Application for removal or variation of a condition following grant of  
planning permission. Town and Country Planning Act 1990.  
Planning (Listed Buildings and Conservation Areas) Act 1990

Amendment to application 20/02346/FUL - Two storey front and two storey rear extension and alterations to fenestration at The Willows Gloucester Road Andoversford Cheltenham Gloucestershire GL54 4HR

20/04239/FUL

Condition no 2 refers to drawing number PL004 Proposed Floor Plans and Elevations, we wish to change this so the condition refers to drawing No PL004 Rev A Proposed Floor Plans and Elevations

Draw no: PL004 Rev A

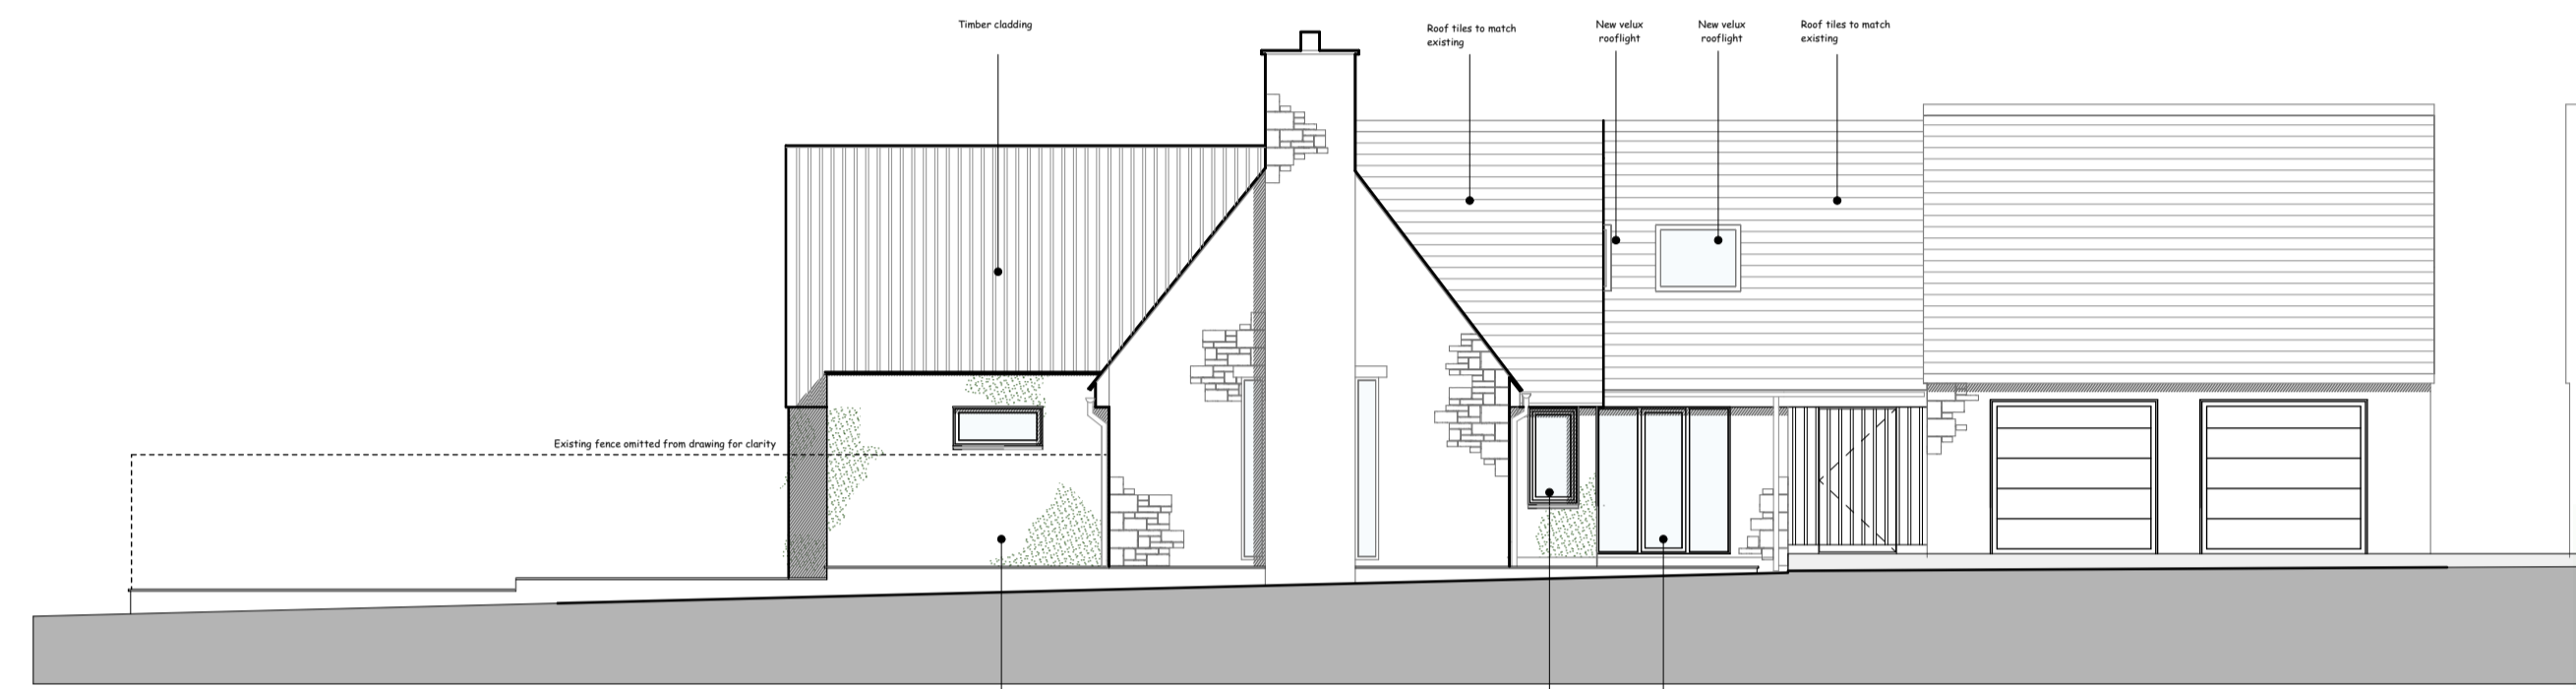
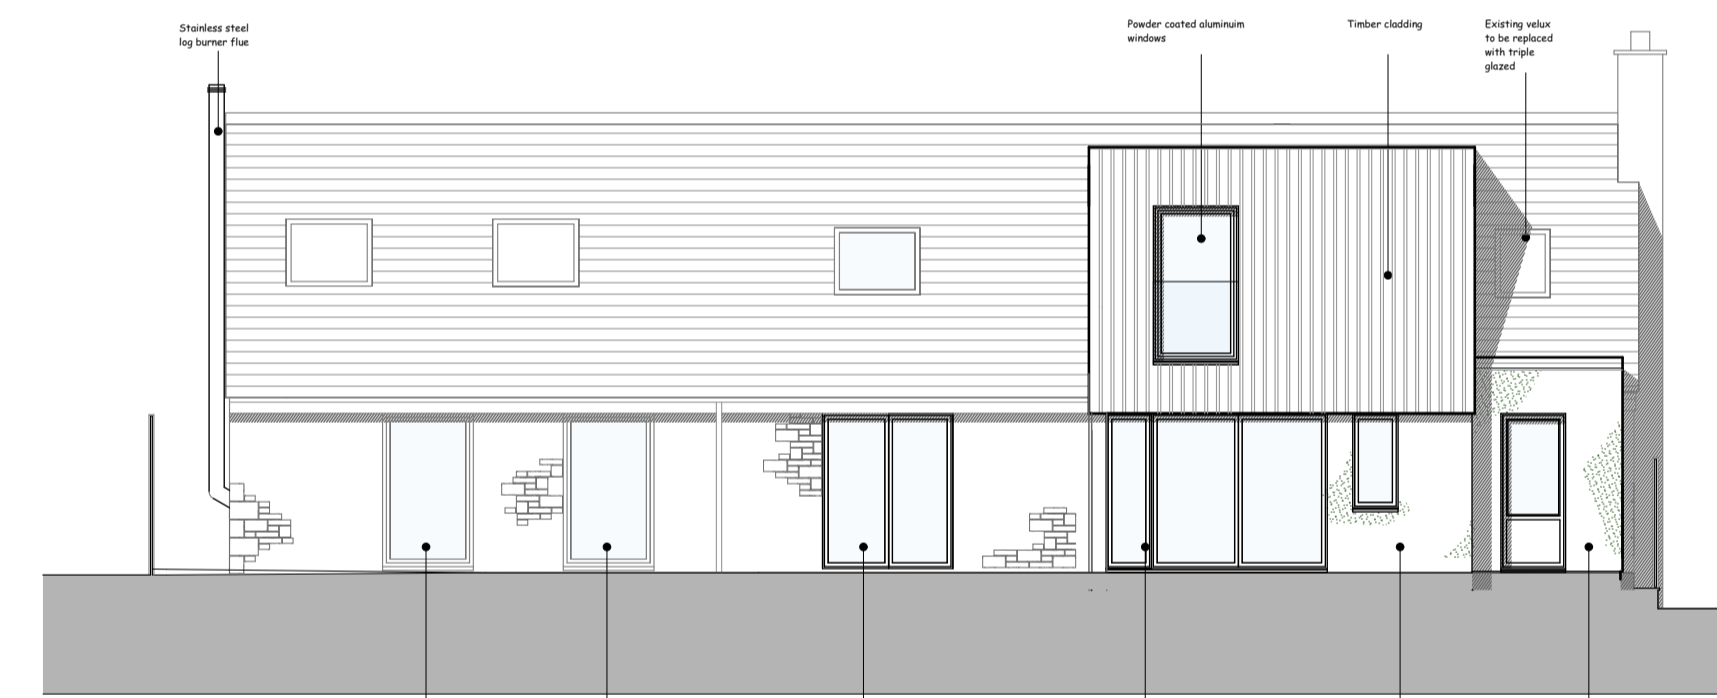
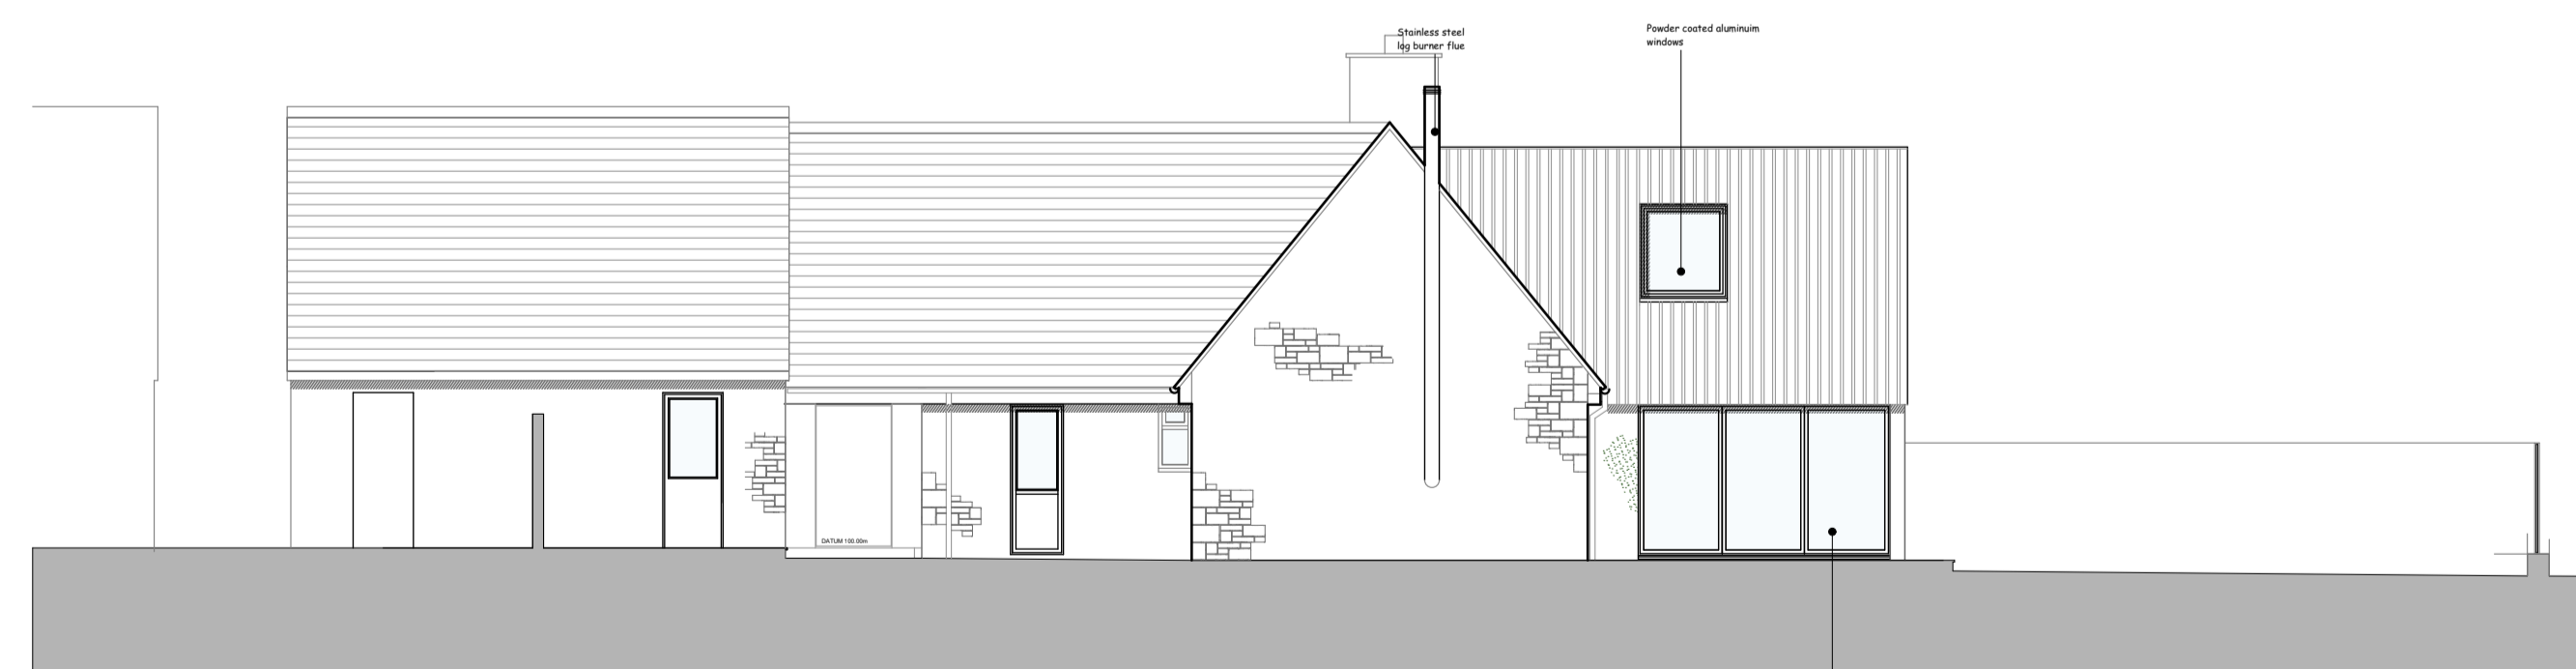
No 2 - We wish to change the material of the front elevation  
No 3 - We have included the details of the proposed materials on the attached drawings

We contacted the case officer to explain that we were not able to obtain the reconstituted stone block to match the recon stone block on the existing house, the house was built in 1968. As such we asked if we could revise the material to be rendered blockwork. We also asked the officer if we could address condition no 3 which related to the approval of the proposed materials at the same time.

Whilst the preference would be for matching stone I appreciate the difficulty and as such would be supportive of an amendment to a rendered finish. I would have some concerns with the use of timber cladding on this elevation owing to its prominence and lack of relation to the rest of the principal elevation.
